PLANNING APPLICATION SUBMISSION: REQUEST FOR ADDITIONAL INFORMATION OR FEE

Reference Number: H08-0591-10

Proposal: Car lot including change of use of existing shop to car showroom

Site Location: 1 Spalding Road Gosberton Spalding Lincs

SITE PLAN

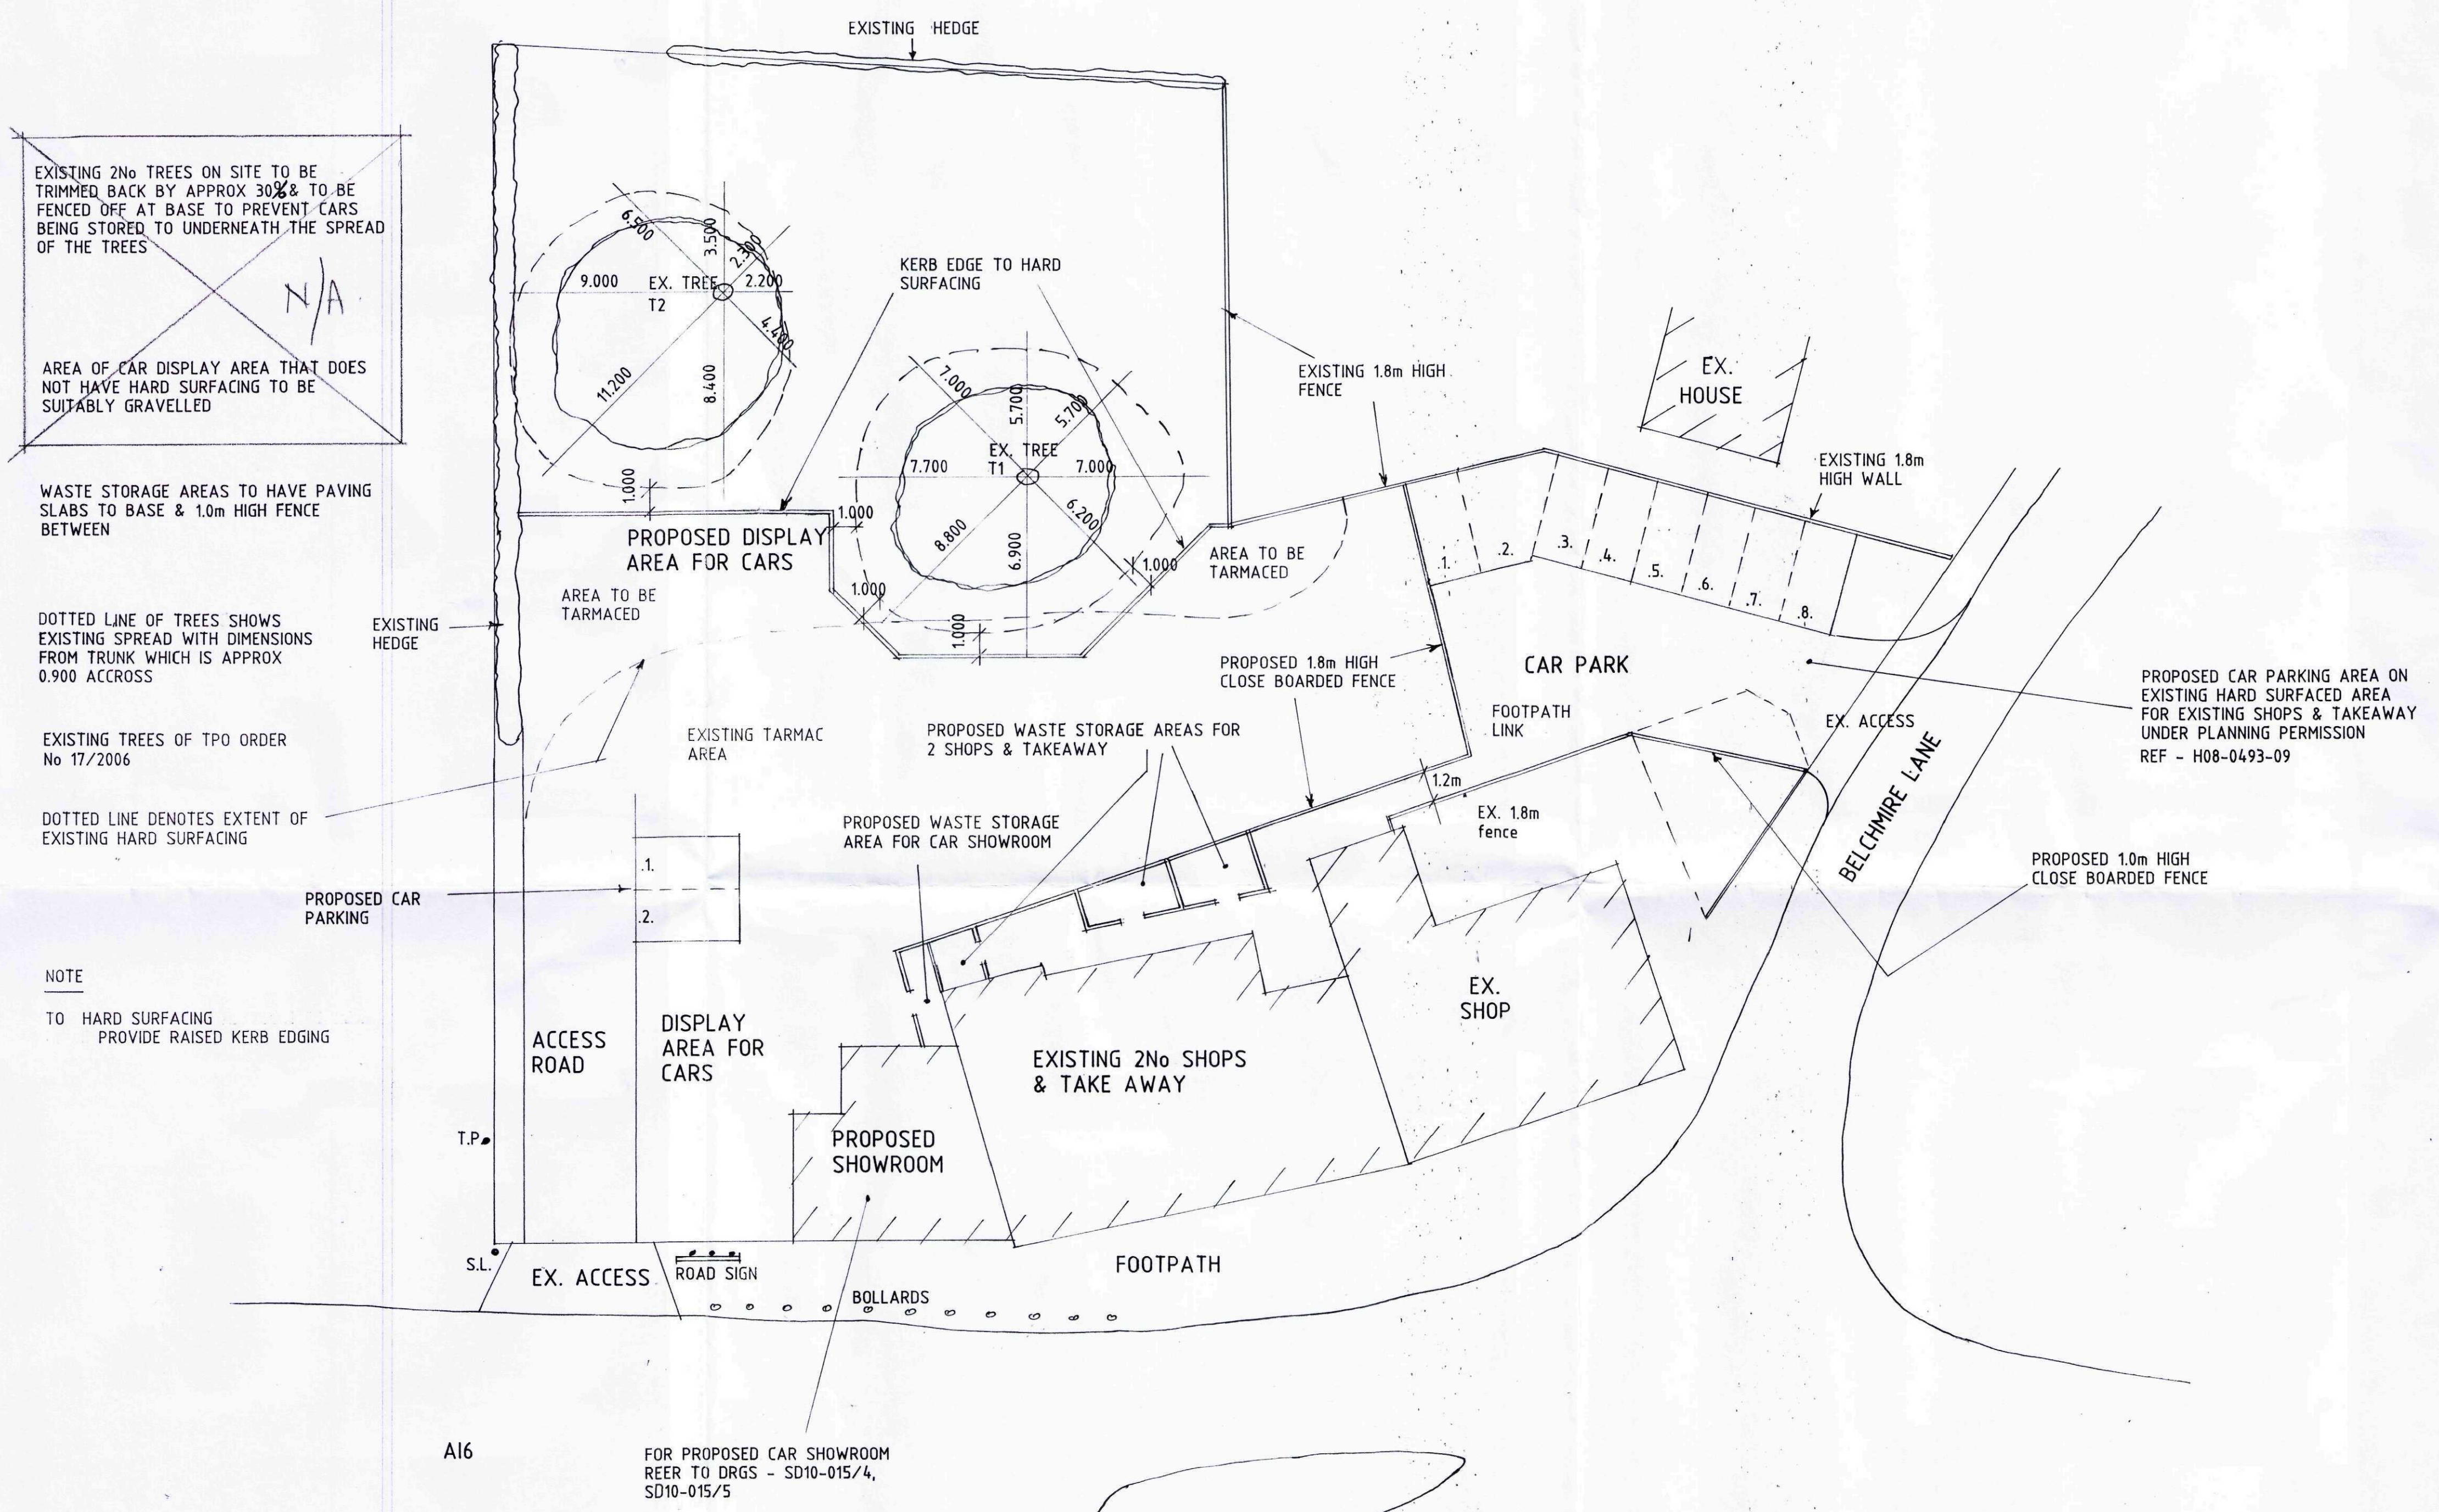
- Please provide an amended site block plan showing the position of fencing at a minimum of 1 metre outside the spread of the existing willow tree canopies.
- Also, please provide an indication of how surface water run-off from the vehicle display hardstanding will be isolated so as to prevent contamination of the Tree Preservation Order Willow trees.

1. 2 no. copies revised site plan drawing no. SD10-015/6C
2. 2 no. copies revised Ordnance Survey map.
3. 1 no. copy of your letter dated 14 September 2010.
